6 September 2011

RE: WAMBO – MONTROSE EAST UNDERGROUND MINE MODIFICATION – RESPONSE TO SUBMISSIONS

RESPONSE TO SUBMISSIONS ON THE
MONTROSE EAST UNDERGROUND MINE
ENVIRONMENTAL ASSESSMENT

Figure 1 – Overlay of A444 and ML 1572

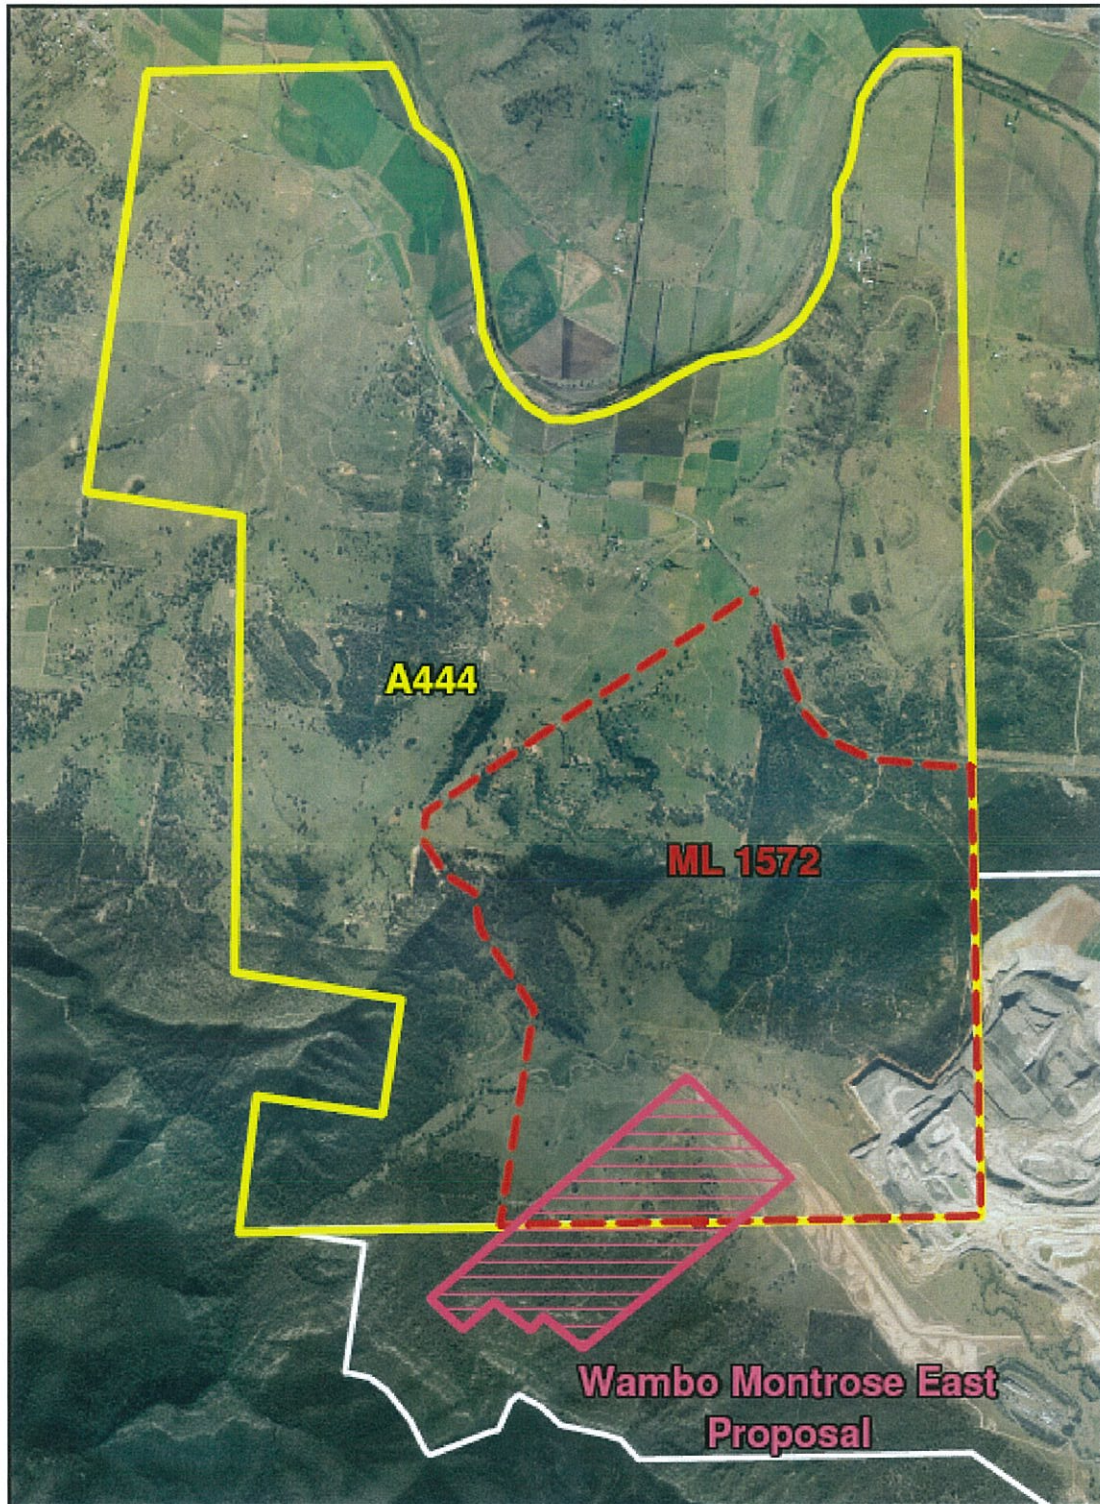
Number	Individual/ Organisation	Submission	WCPL Response
23	United Collieries	<i>The EA does not contemplate the existence of the Exploration Authorisation or any impacts that may arise through the establishment of infrastructure and/or mining of the Proposal on A444 or its joint holders.</i>	United and WCPL have engaged in consultation over a number of years regarding development of their respective interests in the A444 area. Based on information (including indicative mine plans) provided by United to date, there is minimal (if any) impact of infrastructure and/or mining of the Modification on A444. The Modification proposes to mine the Whybrow Seam which is one of the shallowest seams in the area and therefore the Modification should have minimal impact on United Collieries interests in lower coal seams.
24	United Collieries	<i>United requests the Wambo and The Department of Planning and Infrastructure (the Department) continue to liaise with United throughout the assessment period as to the extent of any impacts the Proposal may have on United's interest in A444 ...</i>	WCPL will continue to liaise with United throughout the Modification approval process in accordance with the terms of the existing commercial arrangements between the parties. In addition, the Modification proposes to mine the Whybrow Seam which is one of the shallowest seams in the area and therefore the Modification should have minimal impact on United Collieries interests in lower coal seams.

Figure 2 – Overlay of CL 397, ML1594 and CCL 775

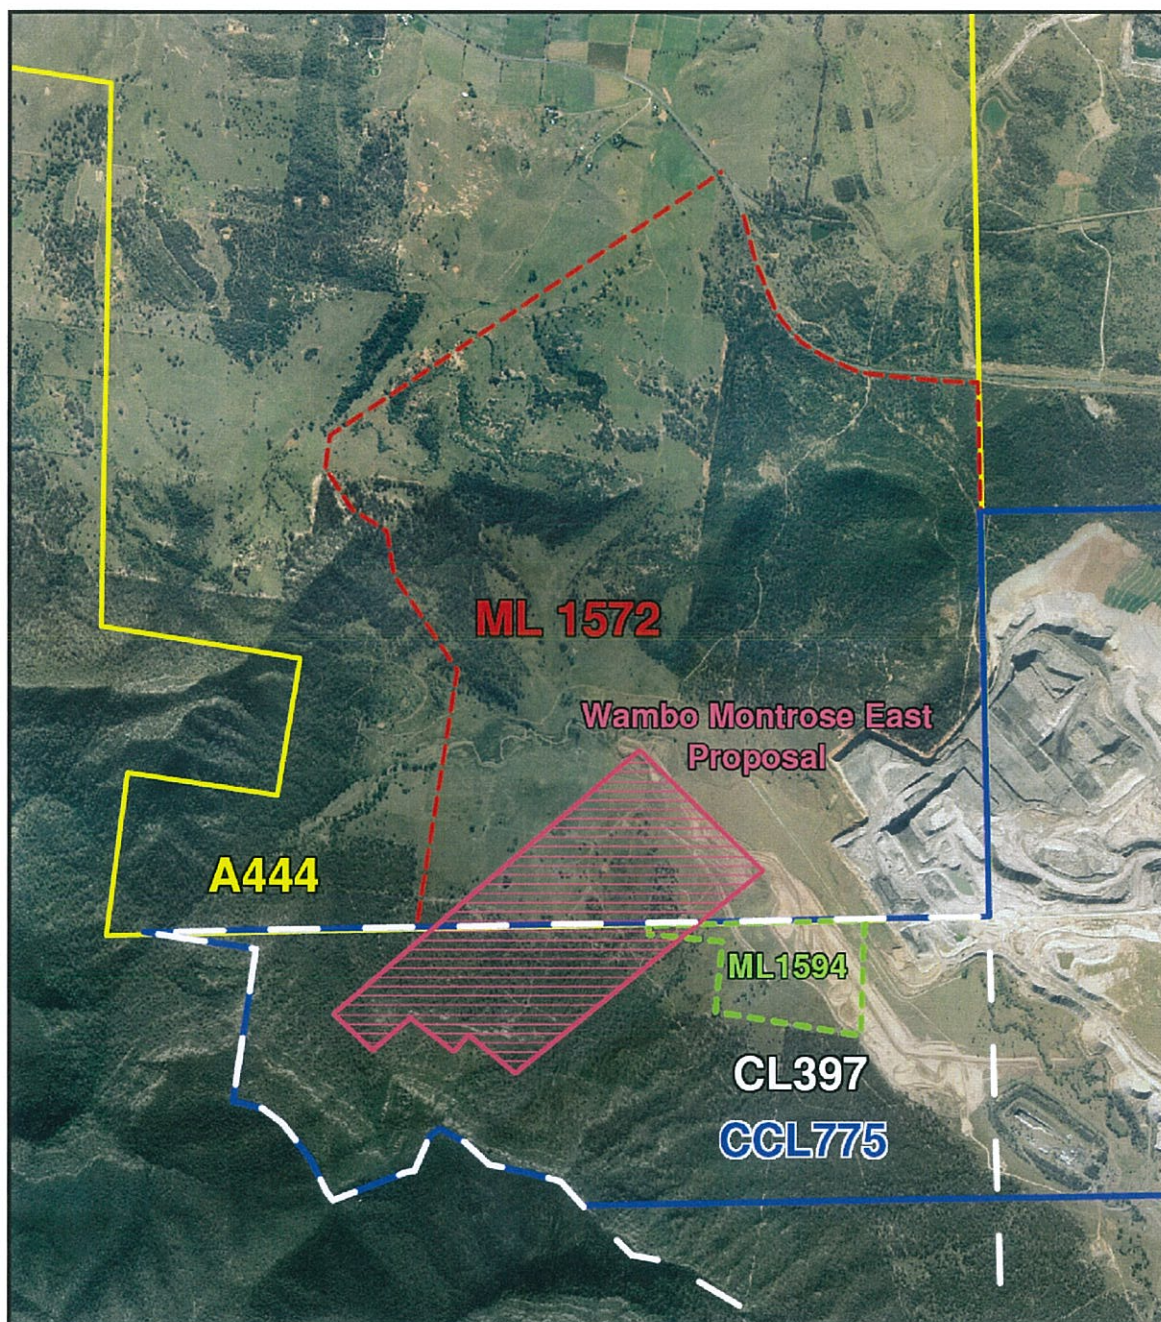
25	United Collieries	<i>The EA does not contemplate the existence of CCL775 or any impacts that may arise through the mining of the Proposal on CCL775 or its holders.</i>	Consolidated Coal Lease (CCL) 775 will not be impacted by the Modification.
26	United Collieries	<i>United requests that Wambo and The Department continue to liaise with United throughout the assessment period as to the extent of any impacts the Proposal may have on United's interest in CCL775 ...</i>	Consolidated Coal Lease (CCL) 775 will not be impacted by the Modification.
27	United Collieries	<i>Wambo need to ensure that the rights of United's access to A444 and CCL775 as defined in existing commercial arrangements are protected, and as such United request that a limit be set for the timing of the completion of the Proposal consistent with the schedule contained within the EA.</i>	WCPL will continue to act in accordance with its obligations under the existing commercial arrangements between the parties in relation to United's access. The final mine scheduling for the Modification longwall panels will be subject to detailed mine planning, Extraction Plan approval, operational requirements and market conditions. WCPL therefore believes it is not reasonable or necessary to place a condition on the Modification restricting the mine life of the Modification longwall panels.
